## STAFF REPORT (updated – 8/6/18) SUNCADIA PHASE 3 DIVISION 14 (LP-18-00002)

TO: Kittitas County Board of County Commissioners  
FROM: Lindsey Ozbolt, Planning Official  
RE: Suncadia Division Phase 3 Division 14 Preliminary Plat (LP-18-00002)  
DATE: August 7th, 2018 [public hearing date]

JOB NO.:	998-722-017
DWG. NAME:	PP-02
DESIGNED BY:	JJH
DRAWN BY:	LGB
CHECKED BY:	
DATE:	03/19/2018
PRINT DATE:	
SHEET	
PP-02

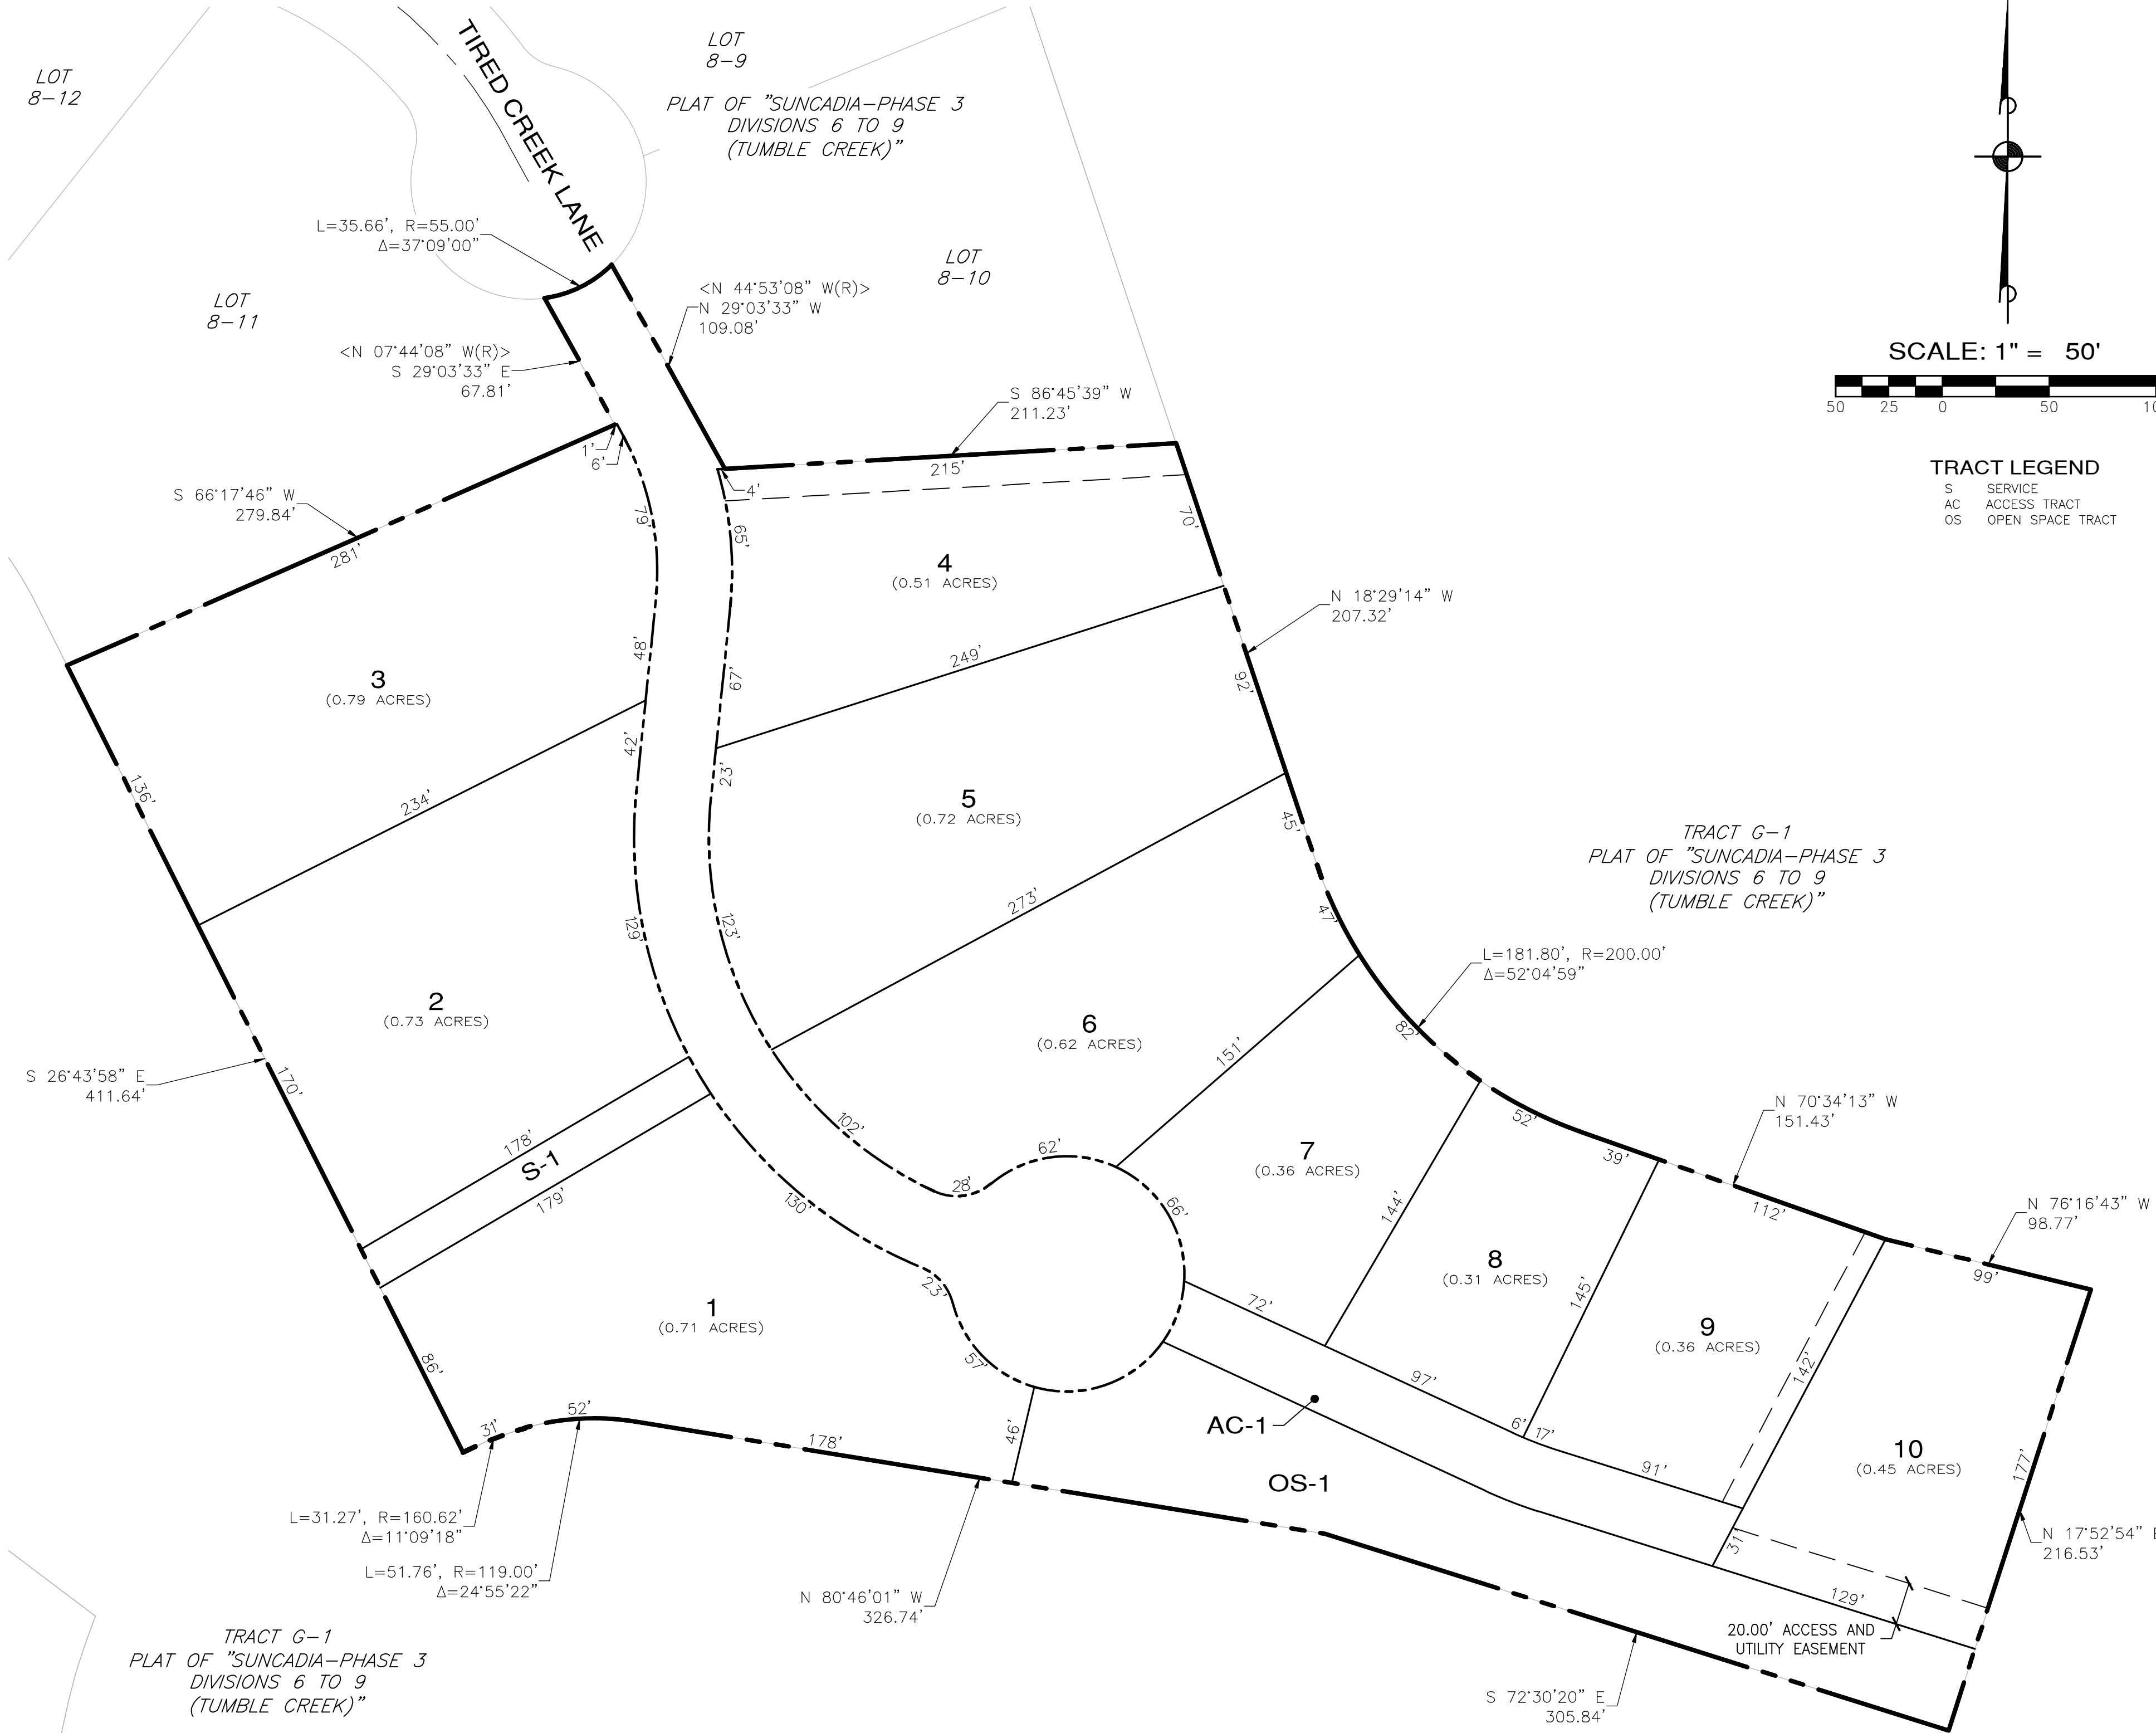
1. The preliminary plat must include a stamp from a licensed land surveyor on all sheets;
2. All pages must include page number and total number of pages;
3. The intended ownership limits of Lot 10 / AC-1 is unclear. Is AC-1 intended to be 20' wide or 30' wide?;
4. Tired Creek Lane should include width, ownership and surfacing; and
5. The lot area tables should include 5-1, AG-1 and OS-2.

Staff Response: Applicant provided a response to PW comments, included as Index #27 of the Master File. The applicant will adhere to all applicable regulations as outlined in the Development Agreement. Revised preliminary plat drawings were submitted and included as Index #30.

8. The Final Plat shall contain the page number and total number of pages on all sheets.
9. The intended ownership limits of Lot 10/AC-1 is unclear. This shall be clarified prior to final plat approval.

10. Tired Creek Lane shall include width, ownership, and surfacing on the Final Plat. (EX: Tired Creek Lane – 30' wide private R/W-Paved)
11. The lot area tables on the Final Plat shall include S-1, AG-1, and OC-1.
